Recommendation Report for Planning Permission

REF NO: R/105/18/PL

LOCATION: Sandon
The Coppice
Rustington
BN16 3TP

PROPOSAL: Change of use of integral garage to form treatment/waiting room, 2 No. dormers to first floor front extension, replacement of rear dormer with 1 No. velux window, balcony to side, change of side window to window & door & 1 No. additional velux to ensuite (amendment to R/45/17/PL).

PROPOSED GROUND FLOOR PLAN

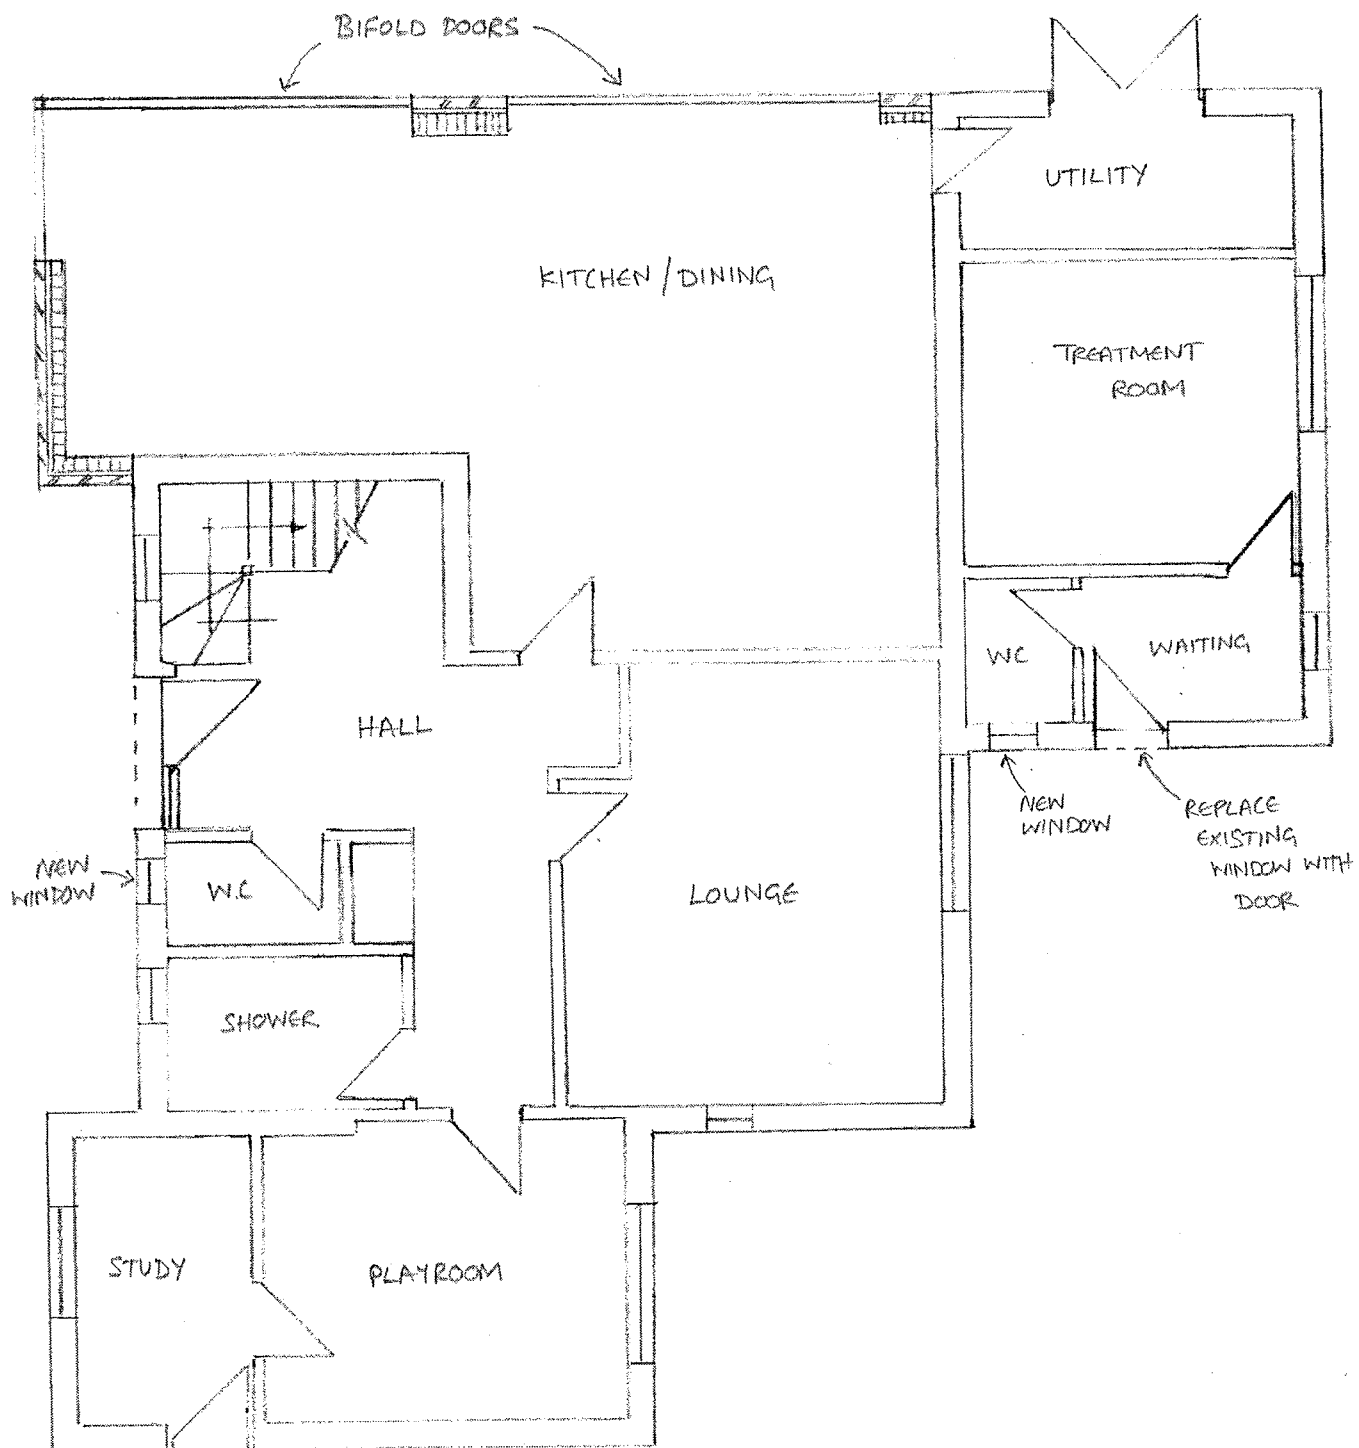
The use of part of the main dwelling for a treatment room could be considered incidental given that it would only utilise a small portion of the of the overall floorspace and given that it would be a low key use unlikely to cause a significant impact on neighbouring properties (i.e. 3 or 4 visitors per day between 9.30 - 5 pm weekdays with up to 3 parking spaces serving the visitors and additional car parking for the residential occupants).

Given that the proposed treatment room would take up a relatively small area of the proposed dwellinghouse, Officers consider that it would be incidental to the primary use of the dwellinghouse and the dwellinghouse use would still remain as the dominant use.

With regard top the proposed folding doors at ground floor level, in the rear extensions, it is considered that no detrimental overlooking would occur as a result of the existing boundary screening.

PROPOSED FIRST FLOOR PLAN

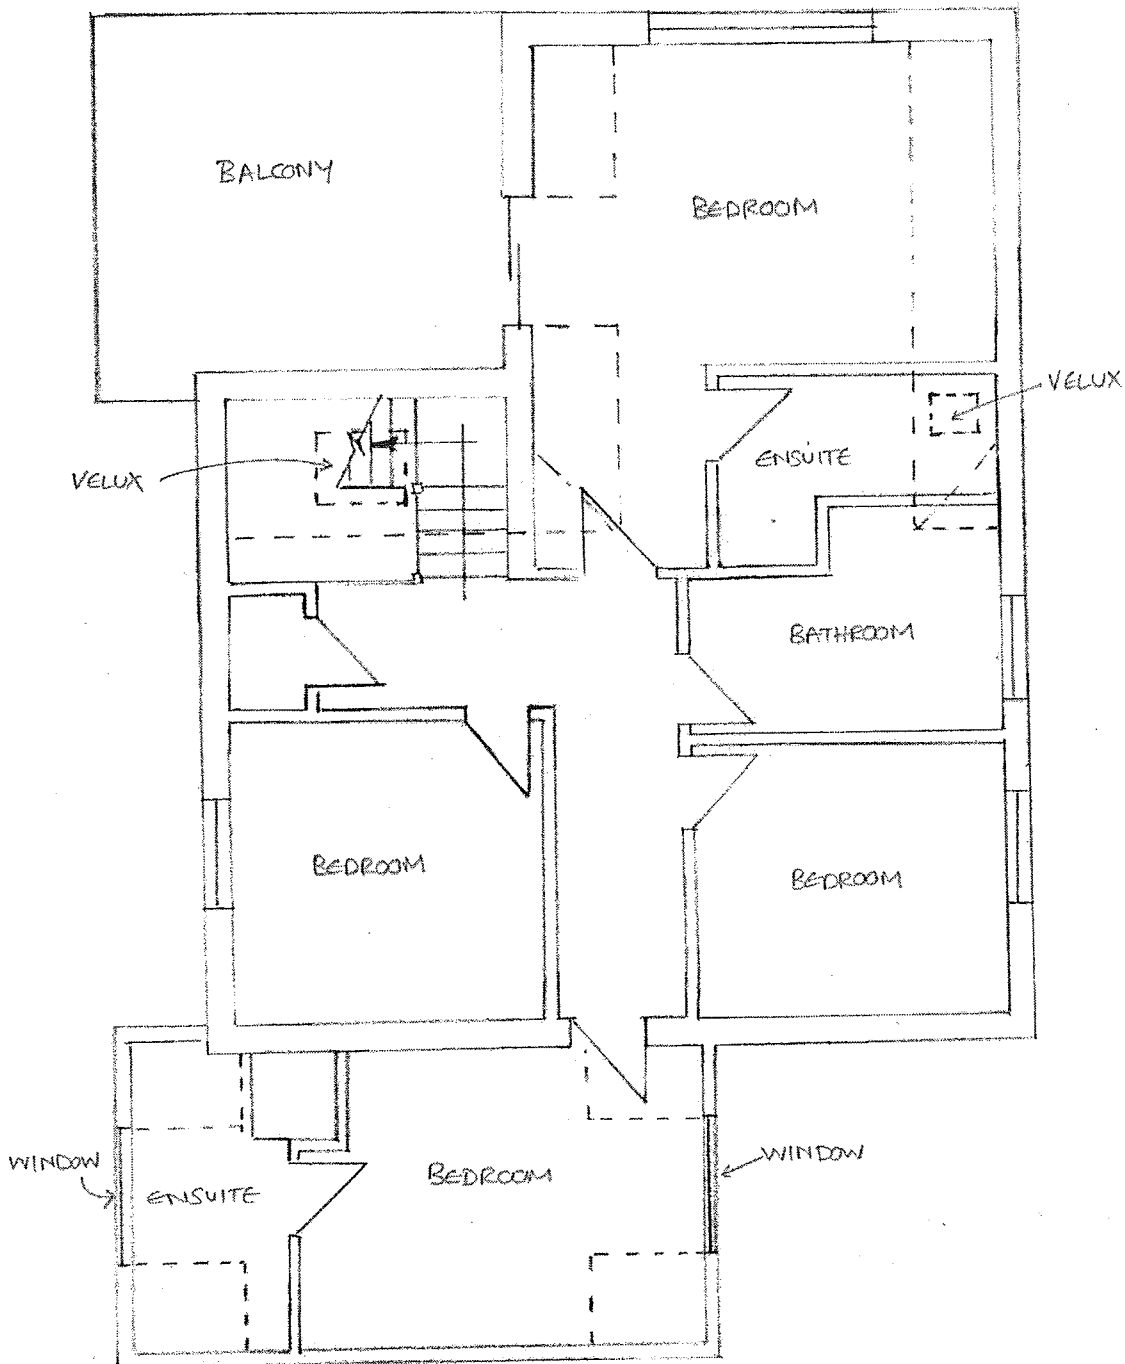
2 dormer windows are proposed into the roofslope of the proposed first floor extension, one in each roofslope of the pitched roof. The dormer windows would serve a bathroom and a bedroom. Any views out from these dormer windows would be out toward the front areas of adjoining properties Cranbrook House and the Coppice Surgery, areas that are already significantly overlooked.

Officers note that a dormer window is proposed into the into the side roofslope of the rear 2 storey projecting element and would face toward the Coppice Surgery. The proposed dormer window would serve a bedroom and any views toward the Coppice Surgery would be over a distance of over 10 metres with trees and an outbuilding along the common boundary of the surgery providing screening. Therefore it is considered that no materially harmful overlooking would occur toward the surgery.

The proposals also include the creation of a balcony above the proposed flat roof extension at the rear. Given the existing screening along the common boundary of the adjoining surgery, it is considered that no detrimental overlooking would occur from the balcony toward the surgery. Due to the 2 storey rear projecting element providing a level of screening, any views out toward adjoining property Cranbrook House would be toward the tail end of the rear garden rather than to the primary amenity space directly to the rear of the host dwelling. Therefore, officers do not consider that any detrimental overlooking would occur as a result of the proposed balcony.

PROPOSED ROOF PLAN

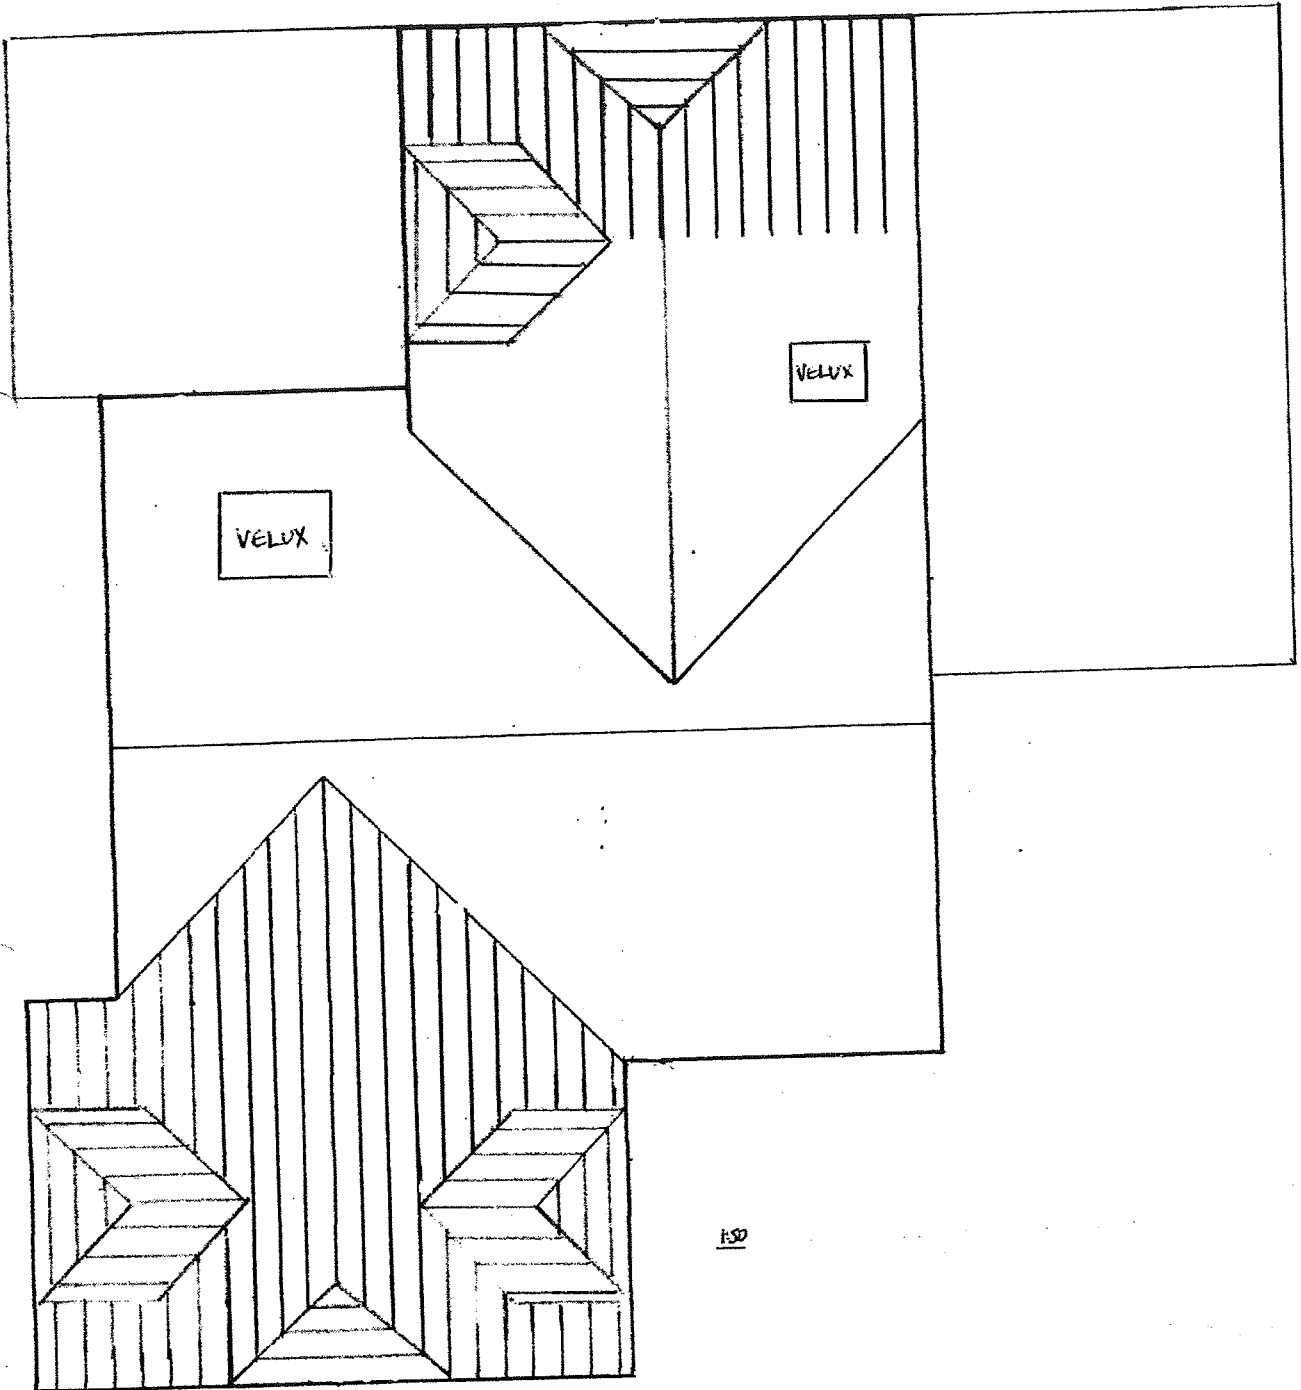
A rooflight, which would serve a stairwell is proposed into the rear roofslope. It is considered that given its positioning within the roofslope, any views out towards adjoining Cranbrook House would be suitably

screened by the roof of the 2 storey rear projecting element. Views would be available out toward the adjoining surgery, however given the aforementioned screening along the common boundary it is considered that no detrimental overlooking would occur. Even without the boundary screening Officers do not consider that any detrimental level of overlooking would occur.
